ATTACHMENT A – DETAILED RESPONSE TO SUBMISSIONS TABLE

Table 1 – Record and response to submissions to SSD 10822510

Figure 2 Proposed tree canopy coverage

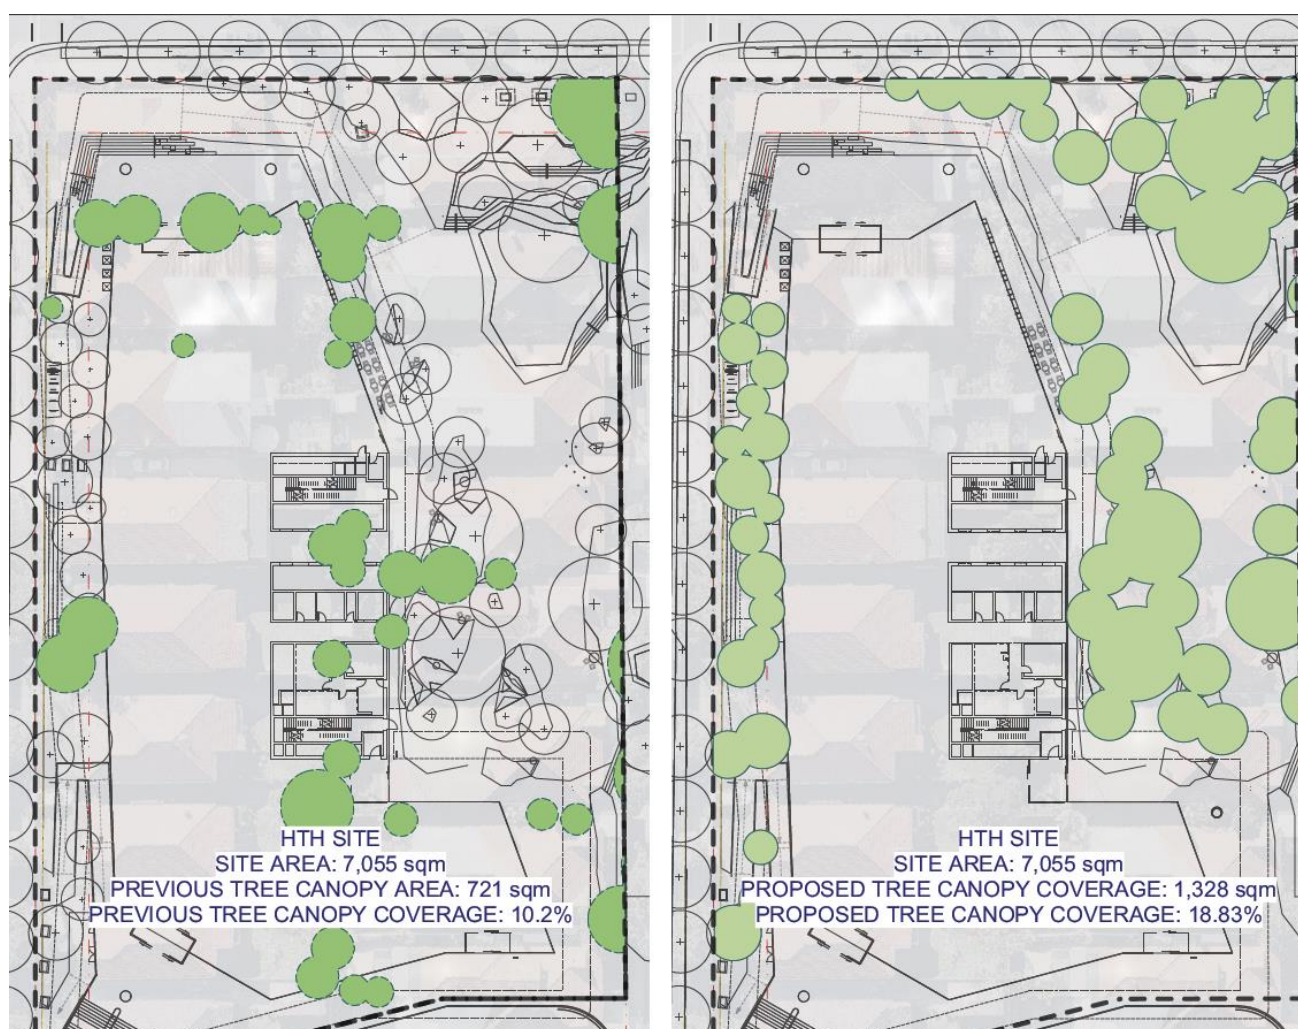
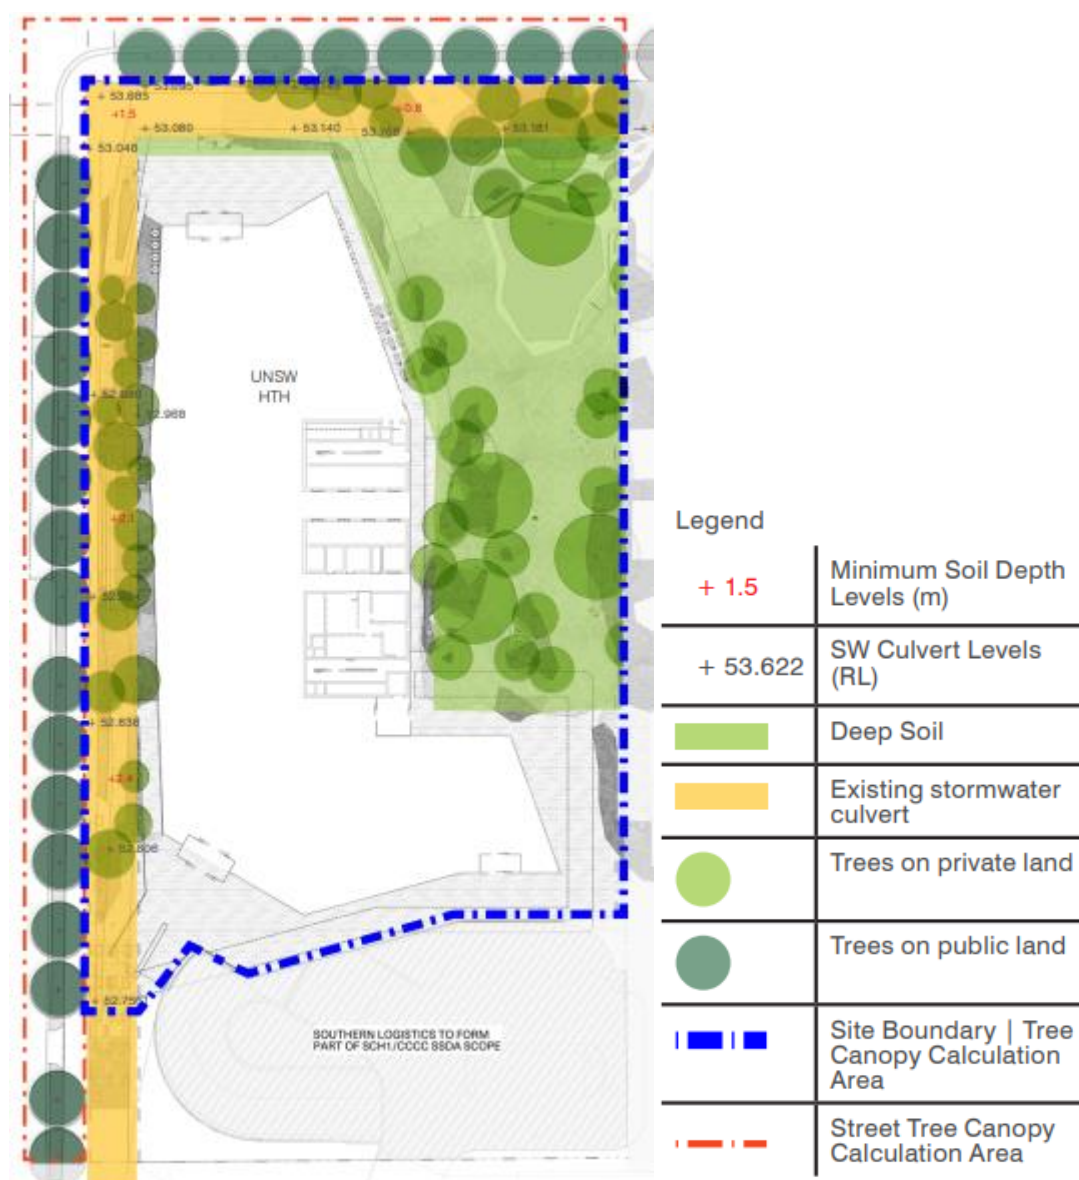
Item No	Name	Type	Issue	Response
2			<p>Canopy Cover and Landscape Plans</p> <p>Consideration should be given to improving tree canopy cover, noting the proposed 14 per cent coverage falls short of minimum 25 per cent recommended within the NSW Government Architect's Draft Greener Places Design Guide. Any comparisons against the 'existing' canopy coverage to justify the proposed canopy cover should be based on an assessment of the canopy cover of the previous residential use of the site, prior to clearing of the site.</p>	<p>The proposed tree canopy coverage has been increased from 14% to 18.83% (excluding street trees), which is more in line with the recommendations of the Draft Greener Places Design Guide. The additional trees provide the maximum possible coverage capacity within the site whilst also balancing the key precinct principle of maintaining clear, open and intuitive wayfinding. The additional trees have been located where soil depth is appropriate, particularly within the northern landscape embankment and the plaza planters. Tree planting within the stormwater culvert has been restricted to areas which allow for substantial mounding, resulting in greater soil volume. Refer to Item 3 (page 6) of the Integrated Architectural and Public Domain Urban Design Submissions Report and revised Landscape Plans at Attachment B and Attachment D further analysis.</p>

Item No	Name	Type	Issue	Response
37			<p>Sustainability and biodiversity</p> <p><i>It is noted that the proposal includes landscaping and public domain works, including the creation of over 2,500sqm of new publicly accessible open space but only a 14 per cent tree canopy for the HTH development site. Given the creation of new open space, Council recommends a minimum 25 per cent tree canopy cover as per the Urban Tree Canopy Guide within the NSW Government Architect's Draft Greener Places Guide. The Draft Design Guide is recommended for use by State and Local Governments and industry to increase tree canopy across Greater Sydney. An increased tree canopy target would support the measure in the ESD Design report to achieve a landscape cooled naturally through vegetation, especially trees with substantial canopy.</i></p>	The proposed tree canopy coverage has been increased from 14% to 18.83%, which is consistent with the recommendations of the Draft Greener Places Design Guide.
